Office of
Environment
& Heritage

MYUNA COAL PROJECT (10_0080) ENVIRONMENTAL ASSESSMENT

Reference is made to your letter to the Office of Environment and Heritage (OEH) dated 14 March 2011 requesting comments on the Myuna Coal Project (10_0080) Environmental Assessment (the EA) dated February 2011 and prepared by AECOM Australia Pty Ltd.

Figure 1 – Revised Seagrass Habitat and SMZ Plan to Include Pulbah Island

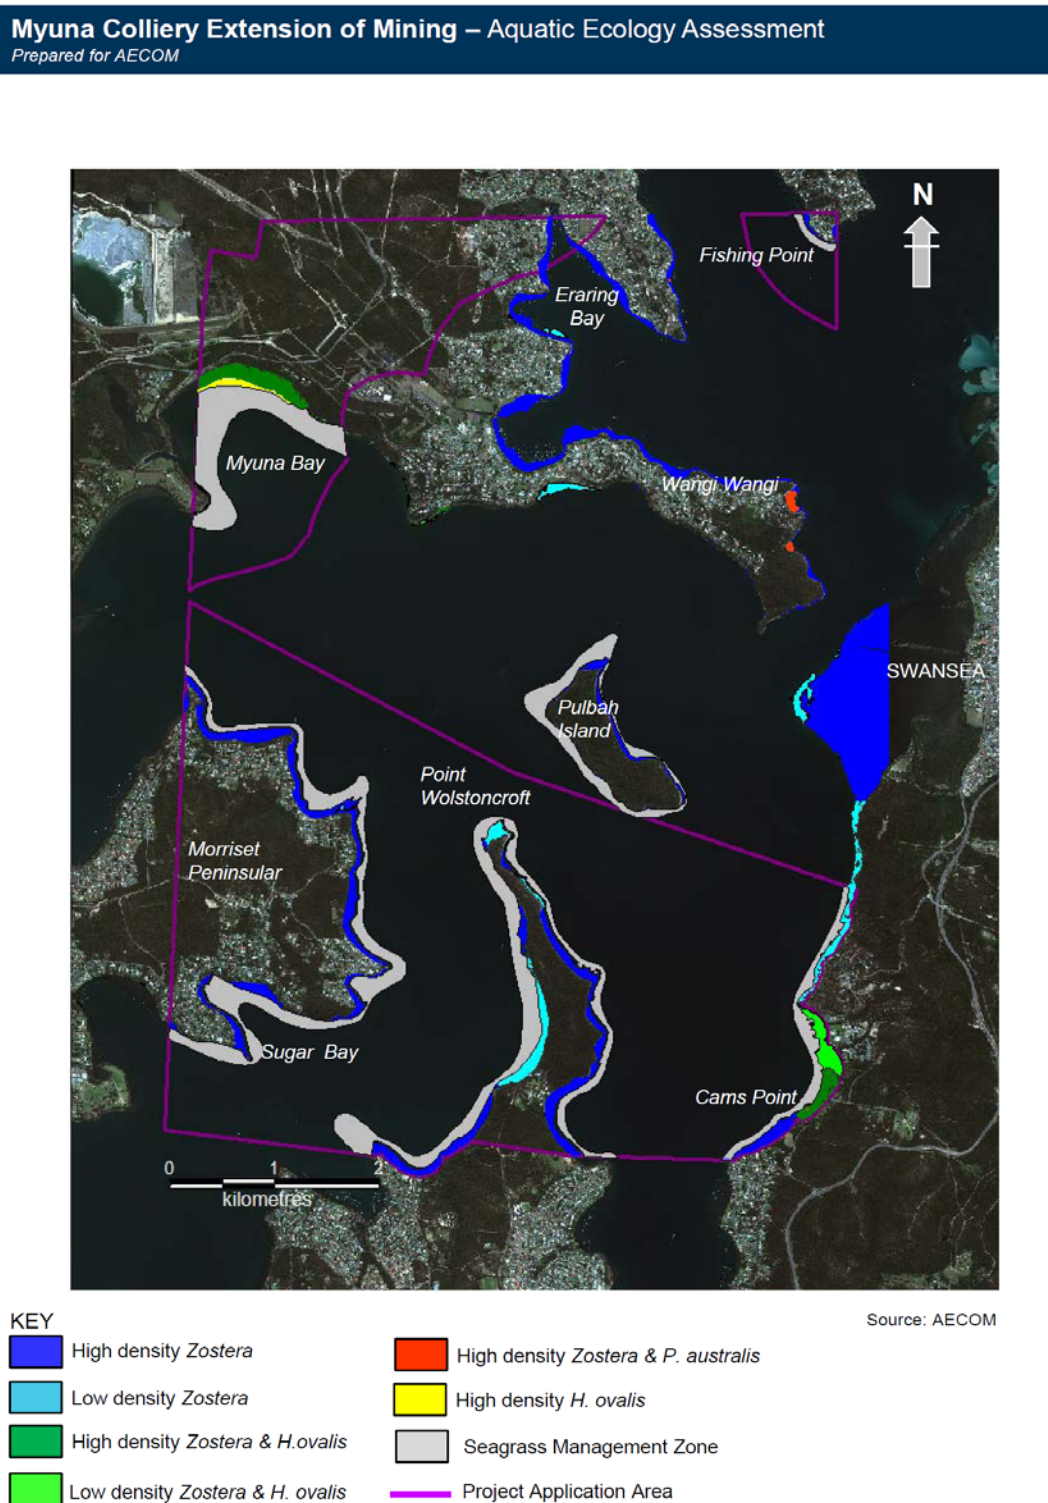
The EA still does not consider the combined effects of mine subsidence, predicted sea-level increases and probable increases in water column light attenuation (due to runoff from increased development in the catchment and any wastewater discharge from the mine) on the benthic ecology.

Furthermore the EA does not address how any impacts will be remediated if subsidence greater than 20 mm does occur in seagrass beds in Zone A. The EA states that "impact of subsidence on seagrasses will be minimal provided that subsidence is less than 20mm in zone A and that seagrass management will be based on a "risk approach".

As stated in earlier correspondence OEH does not support risk based management processes or approaches, and further scientific data is required to ensure the proposed extension of underground mining potential impacts on existing seagrass populations can be assessed irrespective of subsidence rates. A sea grass assessment should be undertaken prior to any additional underground mining activities within zone A and a management strategy developed for monitoring and remedial action to prevent impacts on seagrasses from the proposal. This strategy should not be limited to subsidence greater than 20mm predicted.

While OEH does not find that the EA adequately addresses the impacts of subsidence on the benthic micro and macro communities in Lake Macquarie. The proposal by the proponent to undertake the above mentioned investigations together with a condition within the consent and EPL that no secondary extraction occur prior to undertaking the studies detailed above and that secondary extraction only occur in areas that the studies indicate have effects acceptable to OEH.

OEH as a result of this meeting has agreed with Centennial to include a condition within the EPL limiting secondary extraction and subsidence in areas under Lake Macquarie until this detailed study and model is completed and assessed. It should be noted that it is accepted that if modelling indicates impacts on benthic micro and macro communities in Lake Macquarie secondary extraction may be prohibited in these areas of zone B under Lake Macquarie.
